CITY OF ALBUQUERQUE

RE: **Holly Estates Subdivision**
Ronan and Jenson Court NE
Engineer's Certification Date: 4/5/17
Hydrology File: C21D040

Based upon the information provided in your submittal received 4/6/17, the Engineer's Certification is not approved for Release of Financial Guarantee. The following comments must be addressed prior to Release of Financial Guarantee:

CITY OF ALBUQUERQUE  
PUBLIC WORKS DEPARTMENT  
ENGINEERING DEVELOPMENT GROUP  
HOLLY SUBDIVISION  
GRADING AND DRAINAGE PLAN

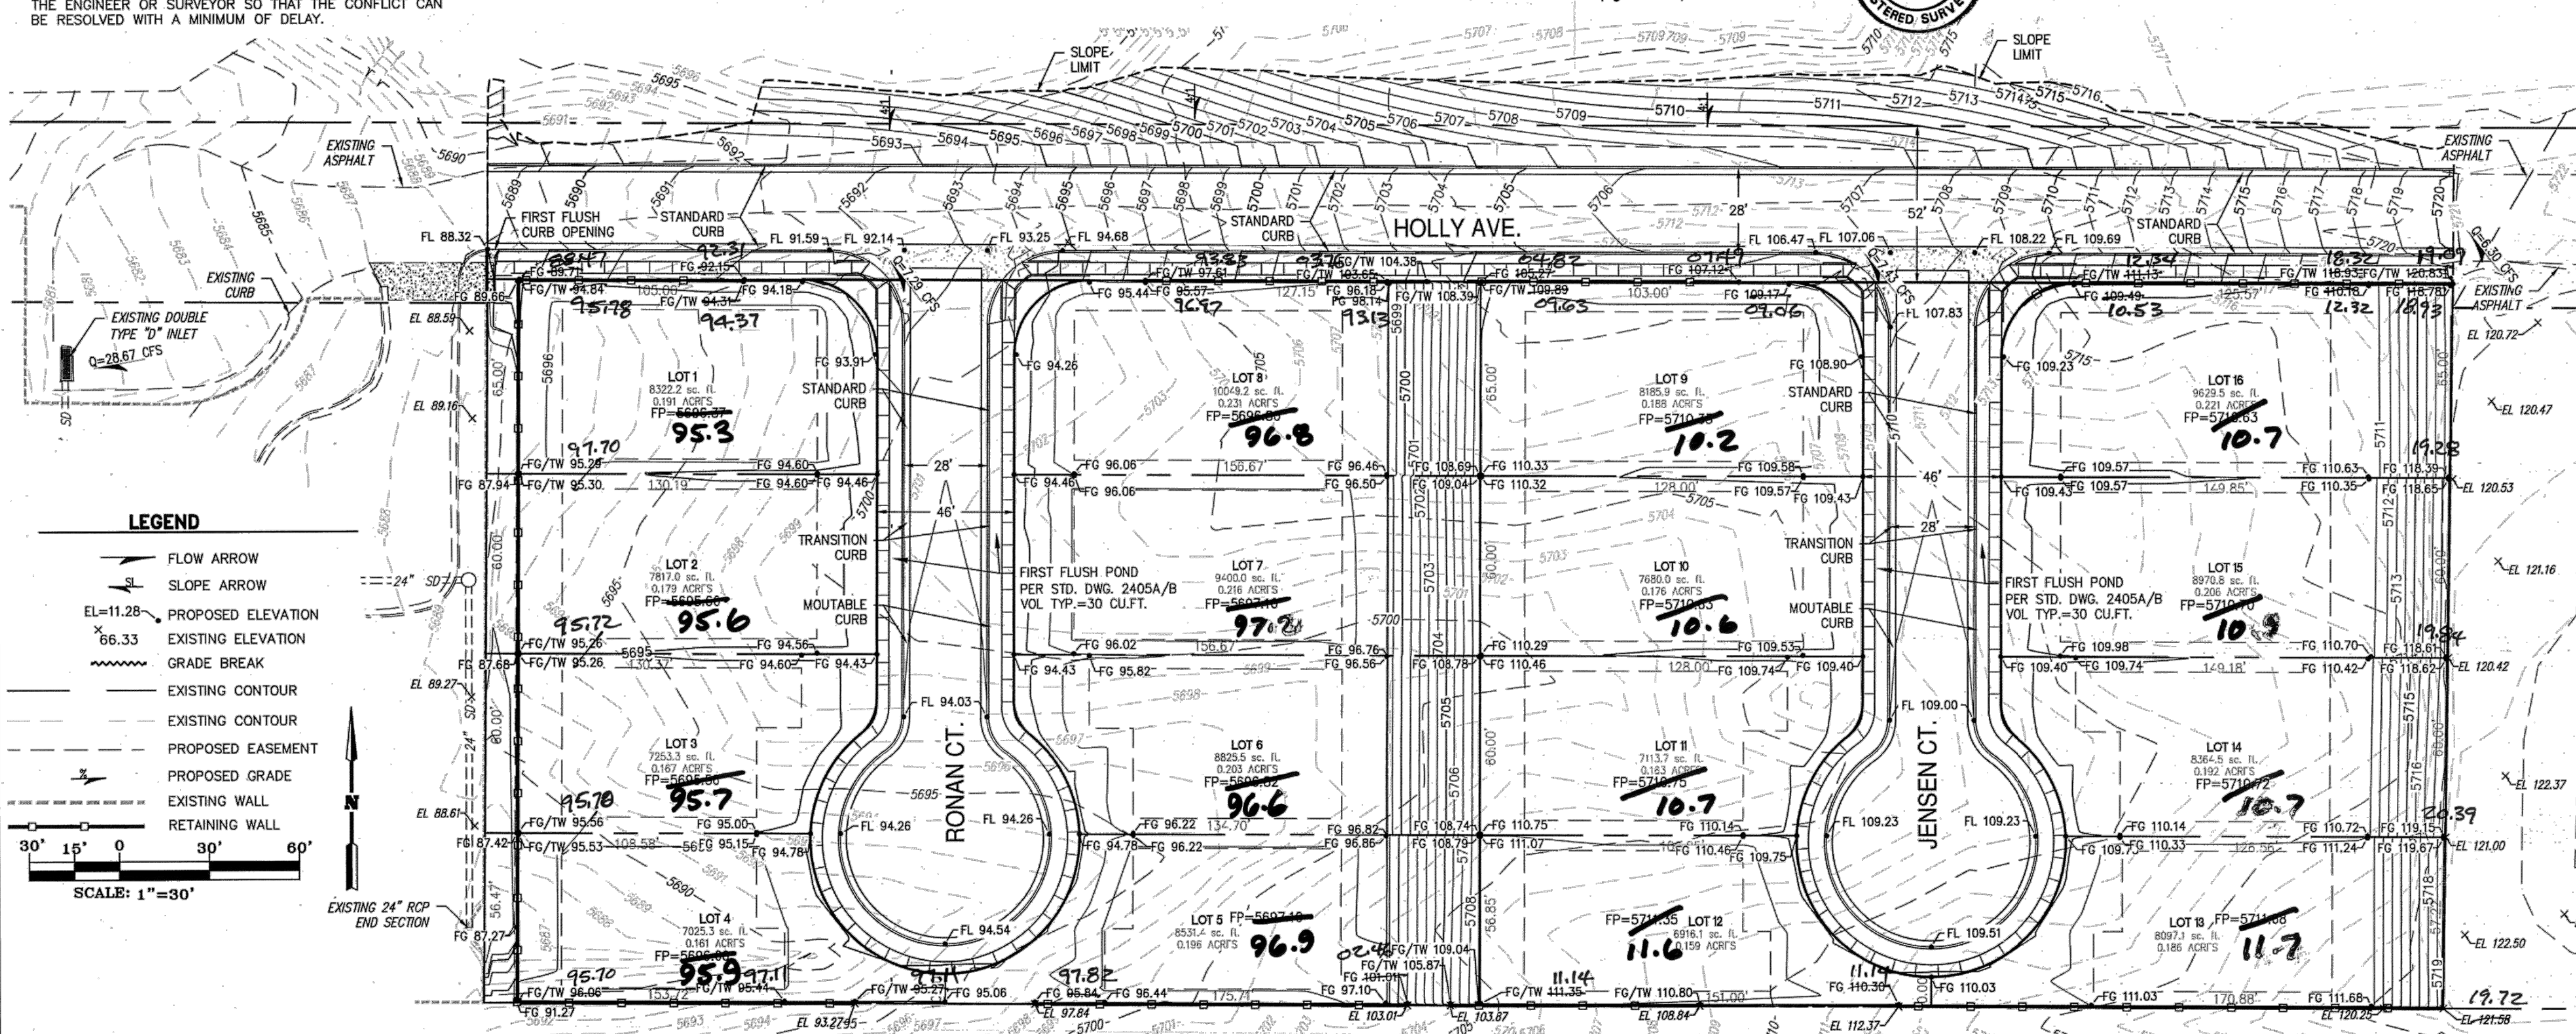
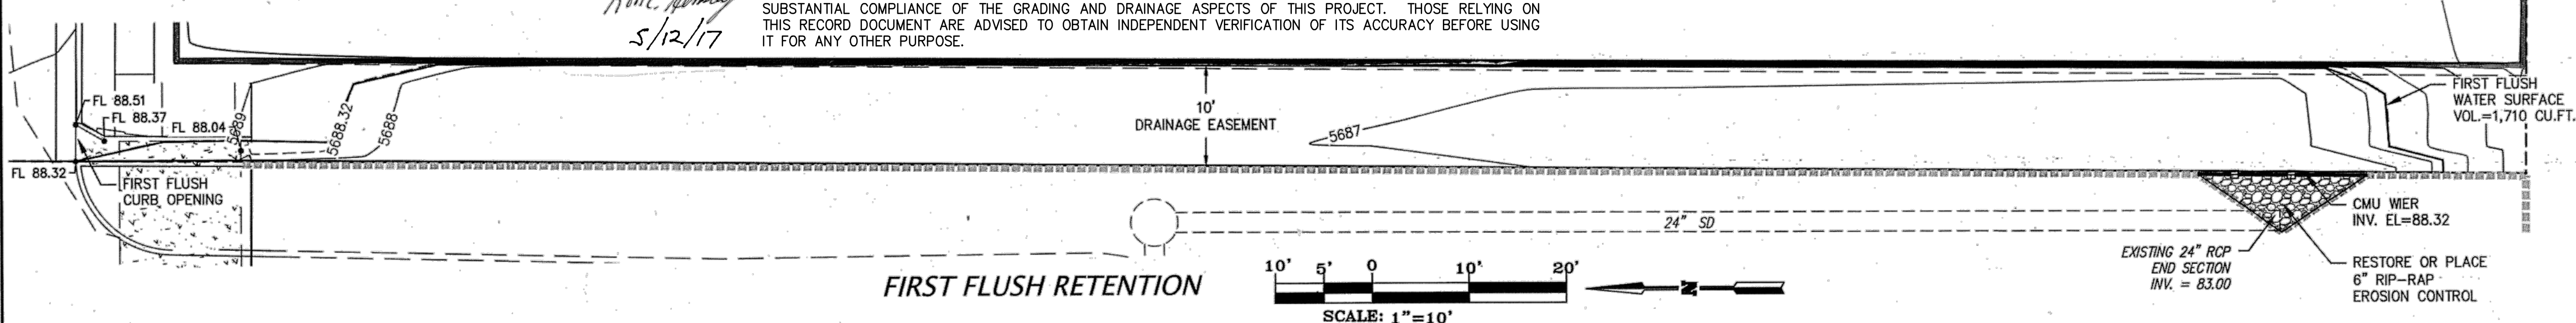
1. Along the north side Lot 9 the flowline is set against the retaining wall. The swale needs to be bladed out here to keep the flowline off the wall.
2. In the southwest corner of Lot 4 there is low ponding area with the flowline set against the wall. Restore positive drainage to Ronan Court.

3. Along the western boundary of lots 1-4, there is a low ponding area that will pond against the high retaining wall. This needs to be bladed to drain back east towards Ronan Court as shown in plans. Alternatively, drain pipe could be placed here to dump directly into the storm water quality pond.

4. The RCP Stub-out outlet for the storm water quality pond is full of sediment and needs to be vacuum cleaned.
5. Place rebar or protective fencing across the RCP Stub-out to prevent accidental entry.

6. Blading out the storm water quality pond revealed a bump up in the adjoining properties' retaining wall. This left the pond about 1 foot deeper than the bottom of the footer. Rebury and restore lateral buttressing to the exposed footer in the immediate area of the exposed footer.

7. Remove "For Information Only" references.
